**TR010037**

**Application by Highways England for an Order Granting Development Consent for the A47/A11 Thickthorn Junction**

The Trustees of the CM Watt Residual Trust's response to the Examining Authority's Written Questions and Requests for Information (ExQ1), issued on 23 September 2021

FIGURE 11.1 - NOISE LOCATION PLAN
TR010037/APP/6.2

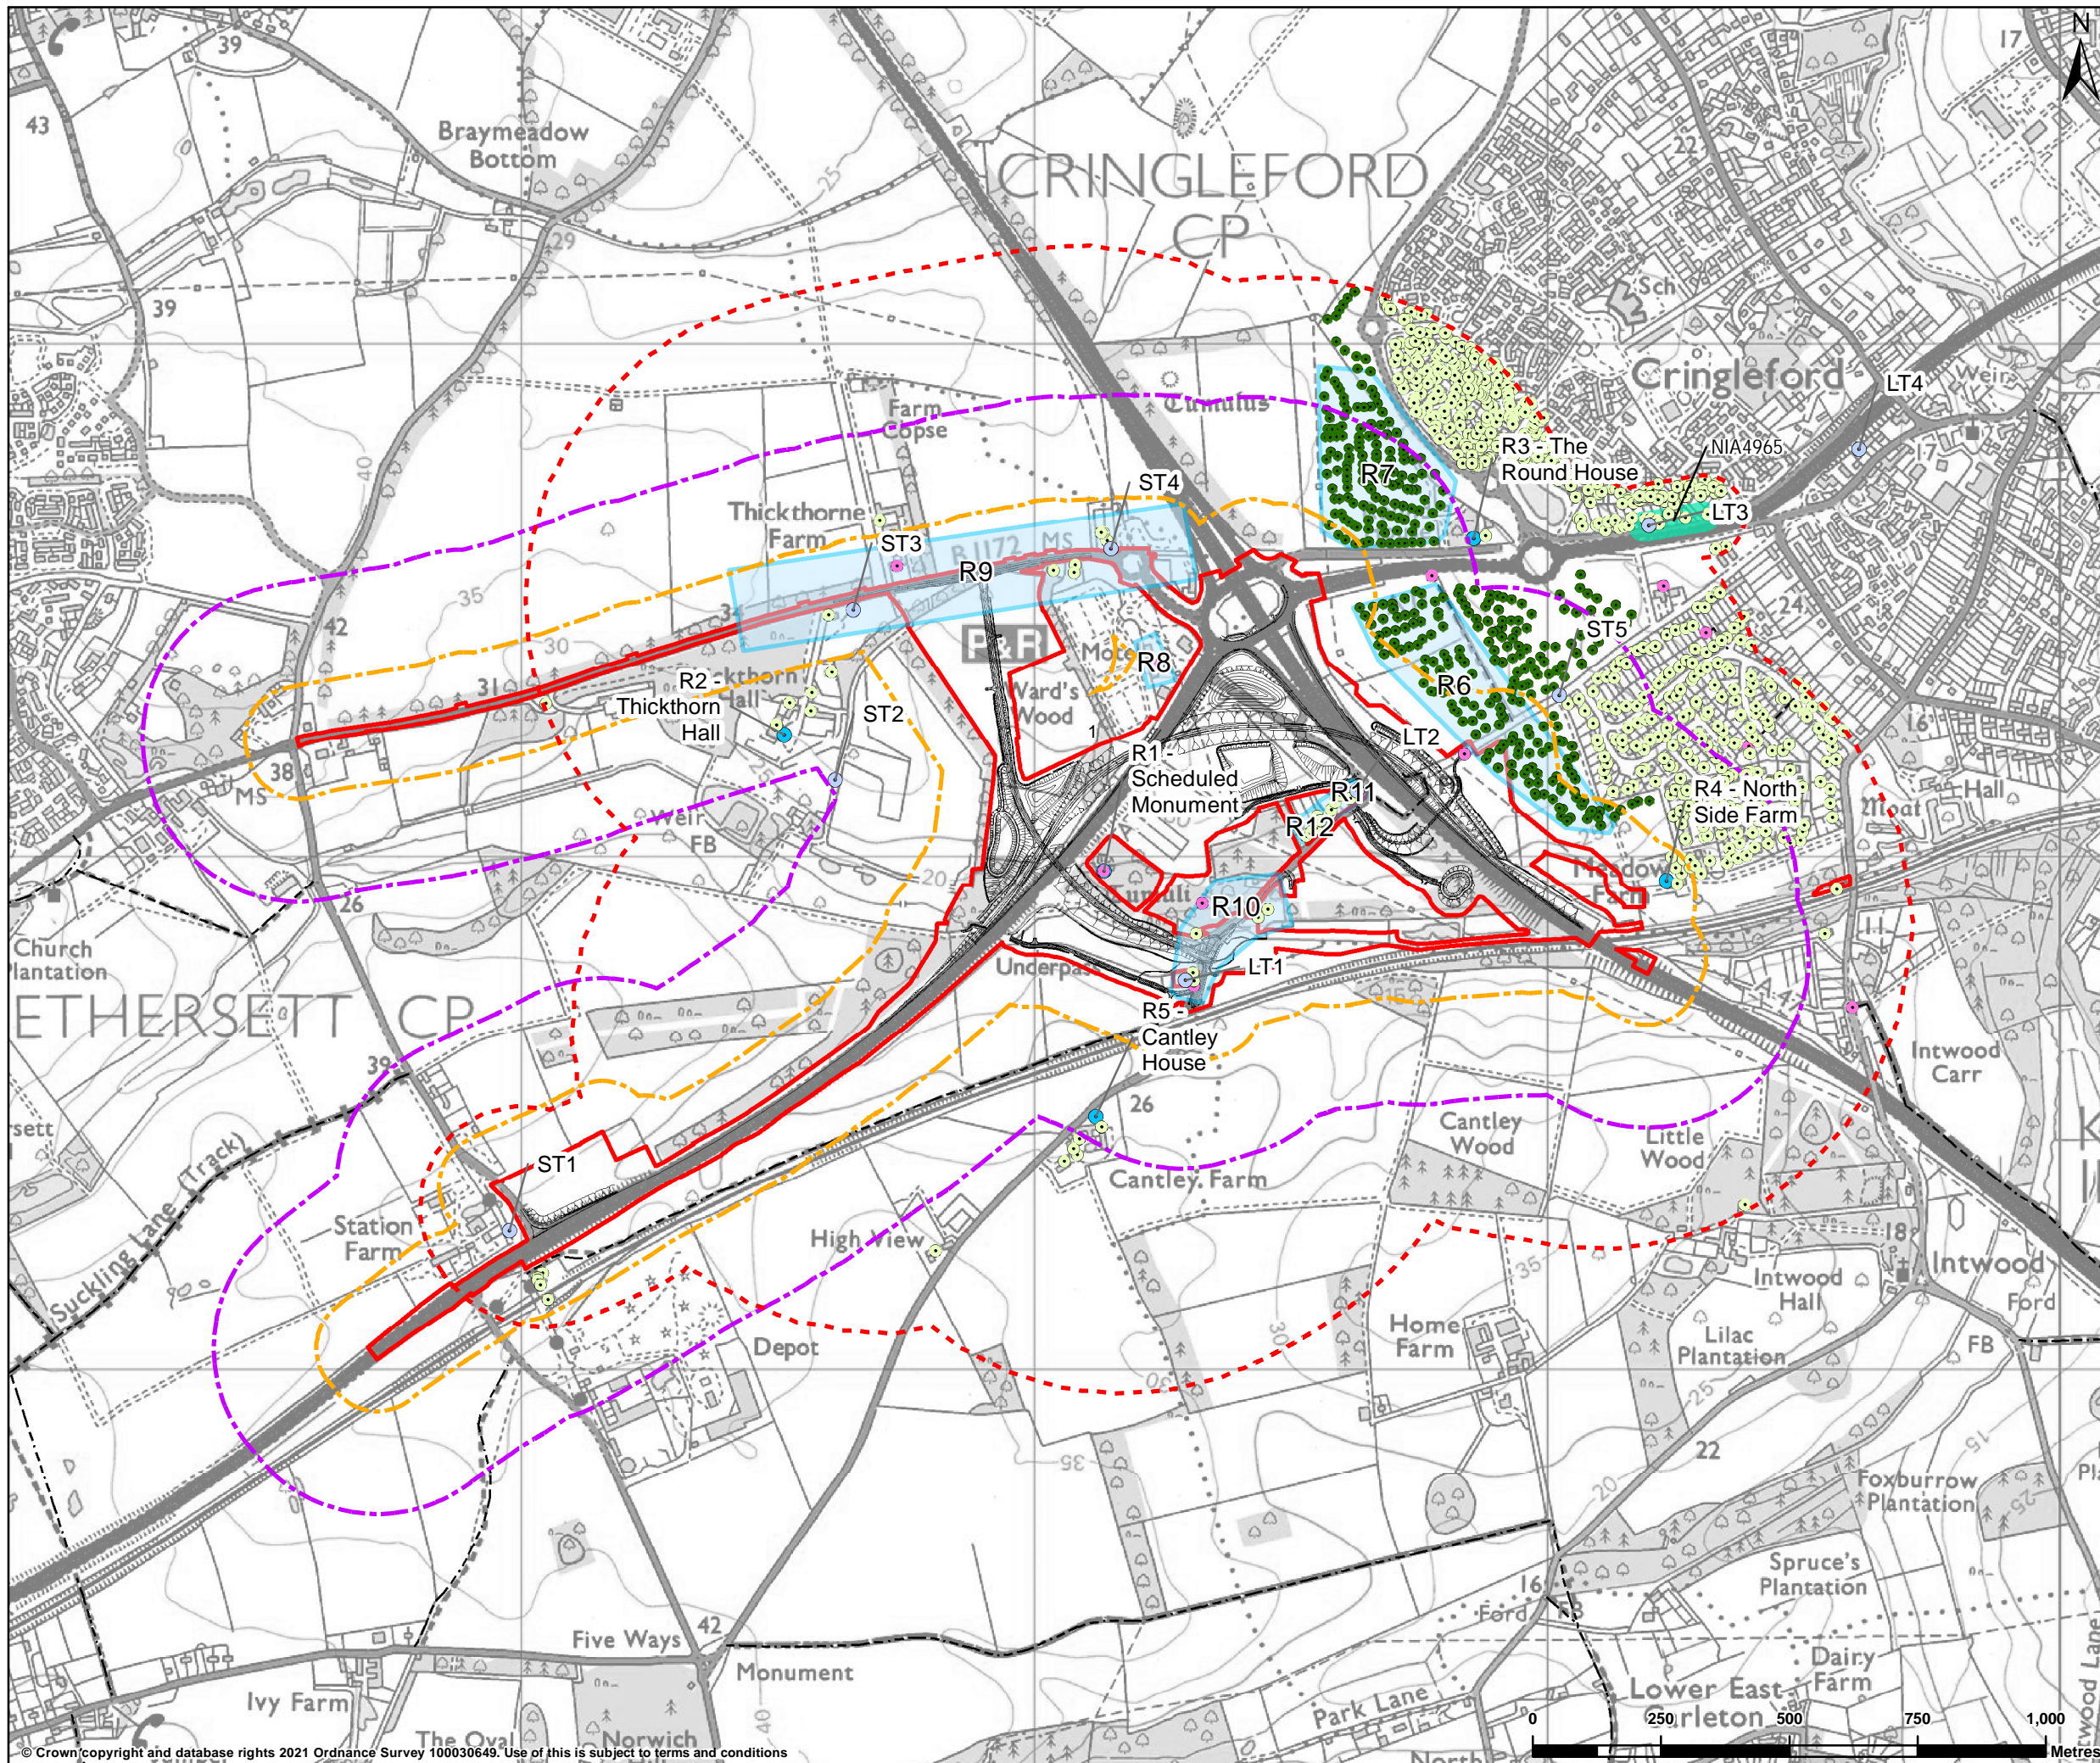
The Trustees are not satisfied that the noise and vibration sensitive receptors have been located to adequately cover all areas which they should and attach an amended version of the Applicant’s Figure 11.1 showing two additional locations, marked by pink Xs, where the Trustees would expect receptors to be placed – Wychwood House and The Old Stables.
